Town & Country Planning Act 1990 (as amended)
Town & Country Planning (Tree Preservation) (England) Regulations 2012

Application for Works to Trees(s) subject to a Tree Preservation Order(TPO)

Development: Fell 1 No. Lime tree
Location: Preston Hall, Timberley The Street East Preston BN16 1HU

THE STREET - EAST PRESTON - BN16 1HU

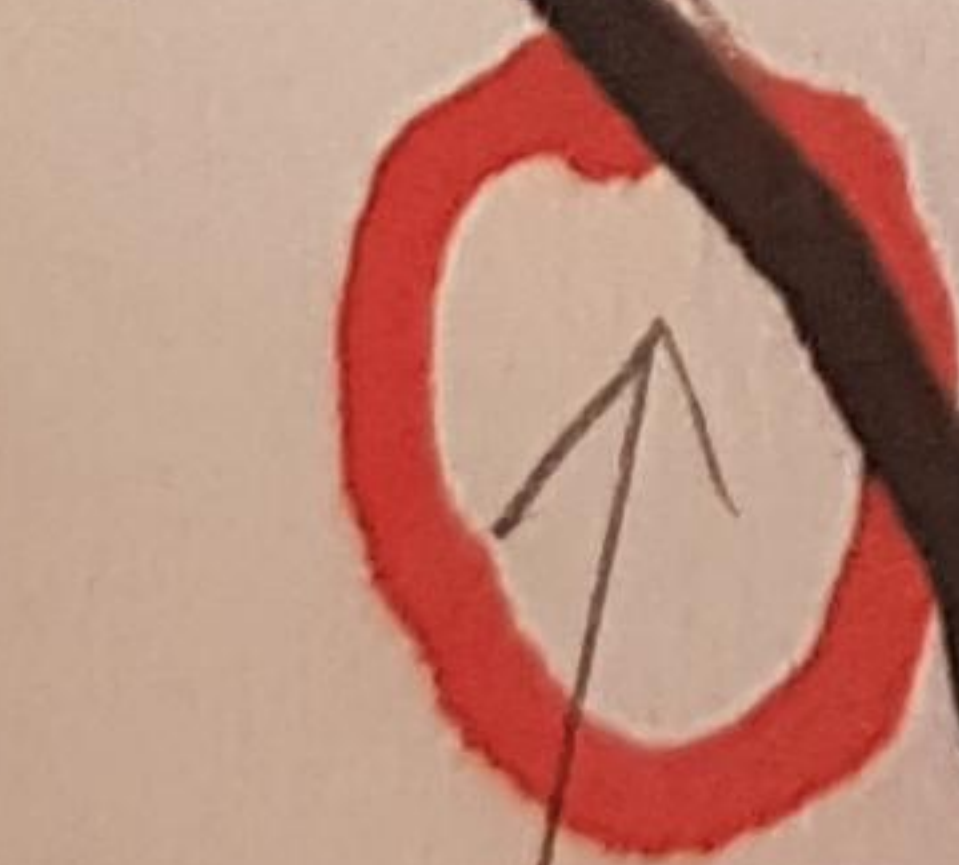
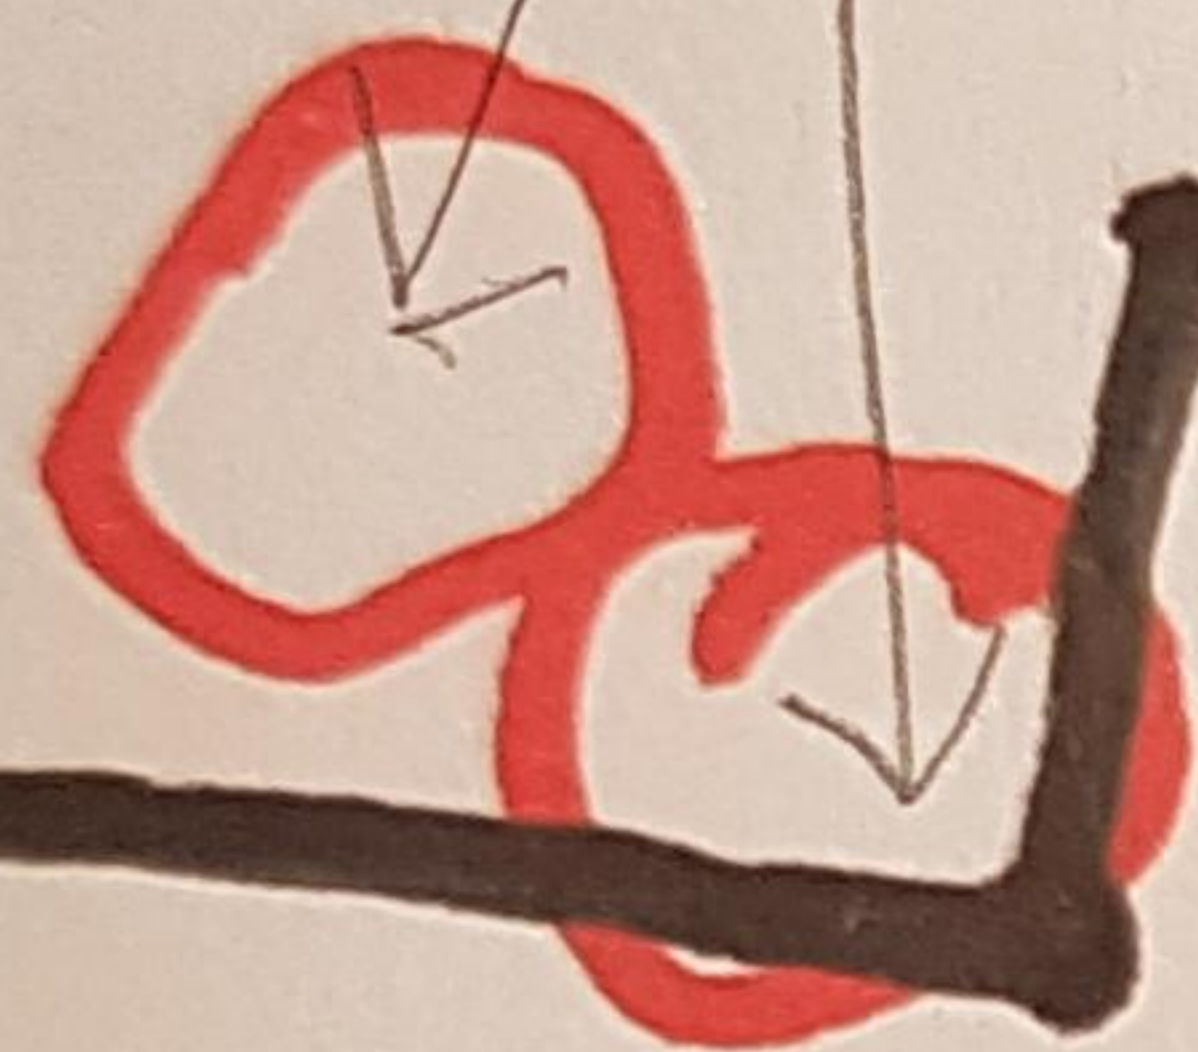
The sketch plan shows 3 trees to be removed, however application is to fell 1 No. Lime tree, please clearly highlight/annotate the tree to be felled re submit.
